Please upload onto Ocella the email below and the attachment from **Angmering Parish Council** objecting to reserved matters application **A/109/20/RES** relating to Land South of Water Lane, Angmering.

Please see the attached objection to A/109/20/RES, due to be heard at Development Control Committee on 6 January 2021.

Angmering Parish Council continues to **OBJECT** to this application. Despite numerous changes to the site layout plans, the applicant has failed to address the majority of the issues raised by the Parish Council.

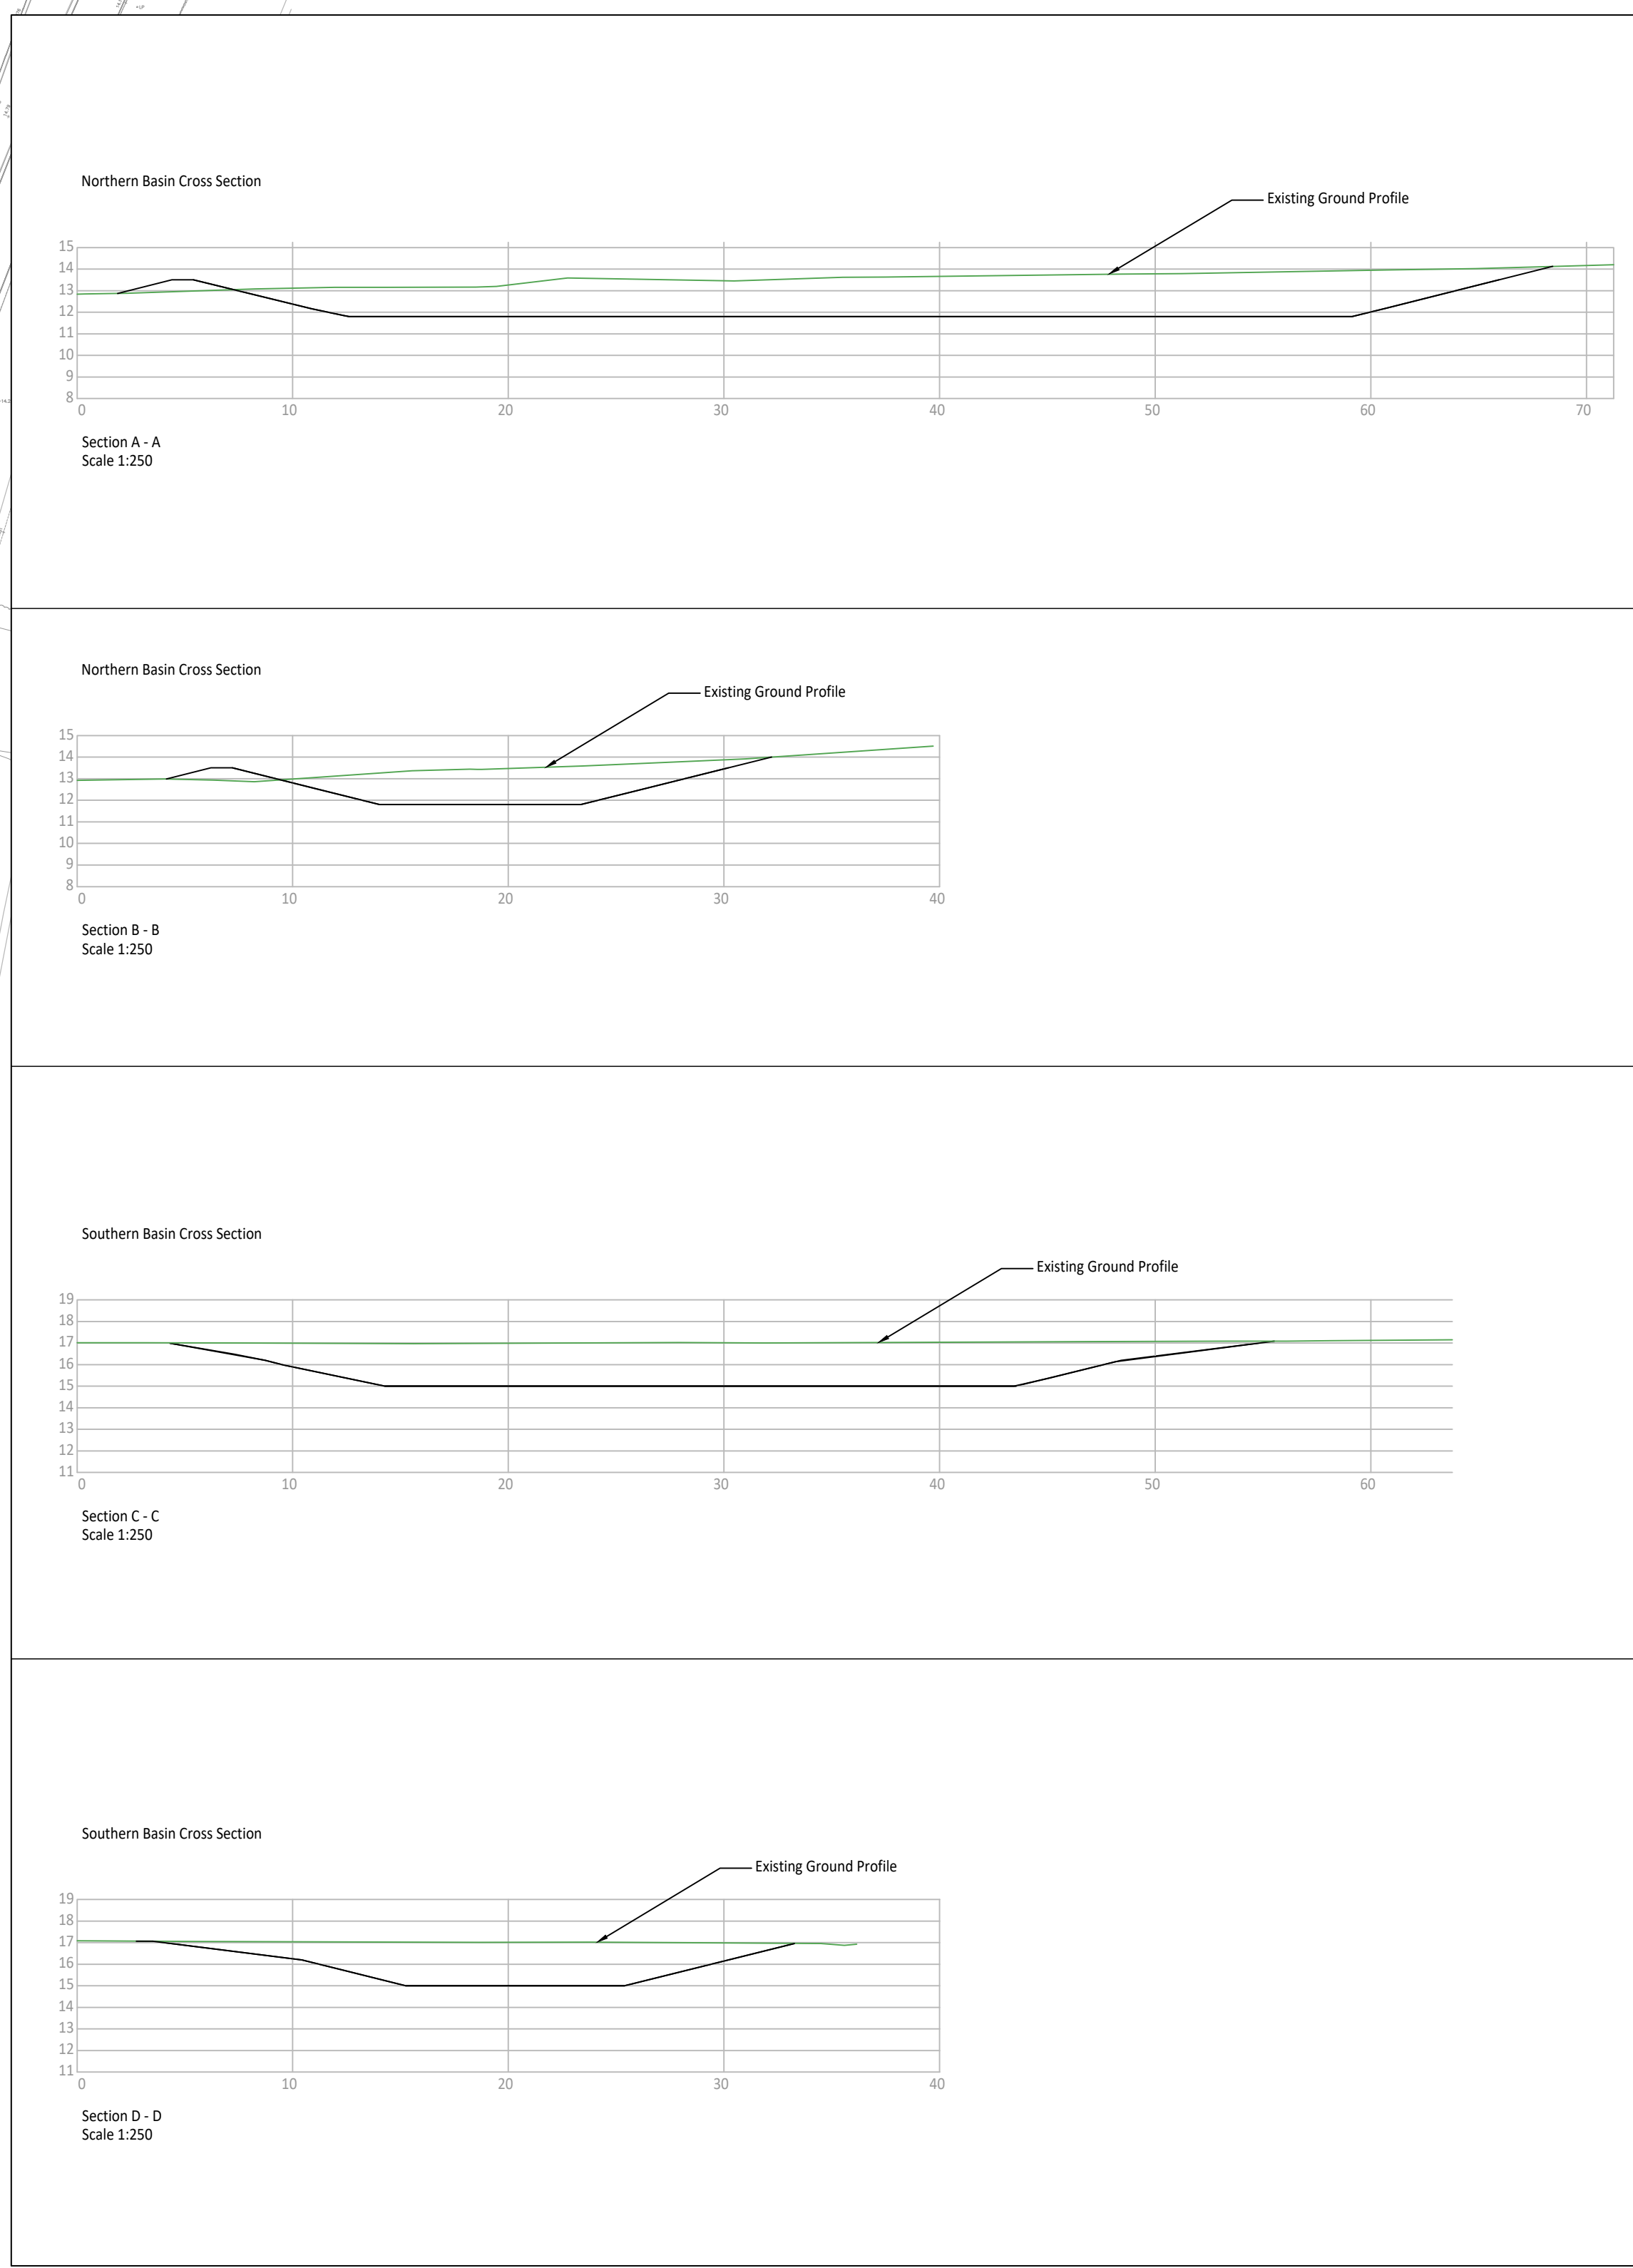
On 25 August, Arun's Drainage Engineer placed a hold on A/109/20/RES, saying ***"It is essential to establish if there is adequate space for surface water drainage prior to agreement of site layout."***

On 1 December, Arun's Drainage Engineer said she was willing to withdraw the holding objection "at this stage", but emphasised that *"further information will be required at discharge of conditions stage to demonstrate that the development's drainage meets policy requirements and fully resolves the comments we have raised as part of this reserved matters application."*

There continues to be insufficient information to establish whether there is adequate space for surface water drainage on the proposed site layout or that the eventual solution will meet Policy requirements.

Information on groundwater monitoring at the basin is still not available, but the applicant is confident (*or rather assumes*) that free volume can be provided within the proposed site layout if wider changes, such as to the pipe network or additional storage, needs to be provided and is willing to provide additional features if required at a later stage.

Infiltration must not be assumed. Retrofitting a drainage solution into an approved site layout, or indeed a completed development, is not acceptable and can lead to poor outcomes. Factors such as groundwater levels may affect infiltration results. Therefore it is essential to complete all outstanding testing, as results could significantly impact on the size and/or design of the drainage system, and as Arun's Drainage Engineer has already pointed out, the proposed site layout.
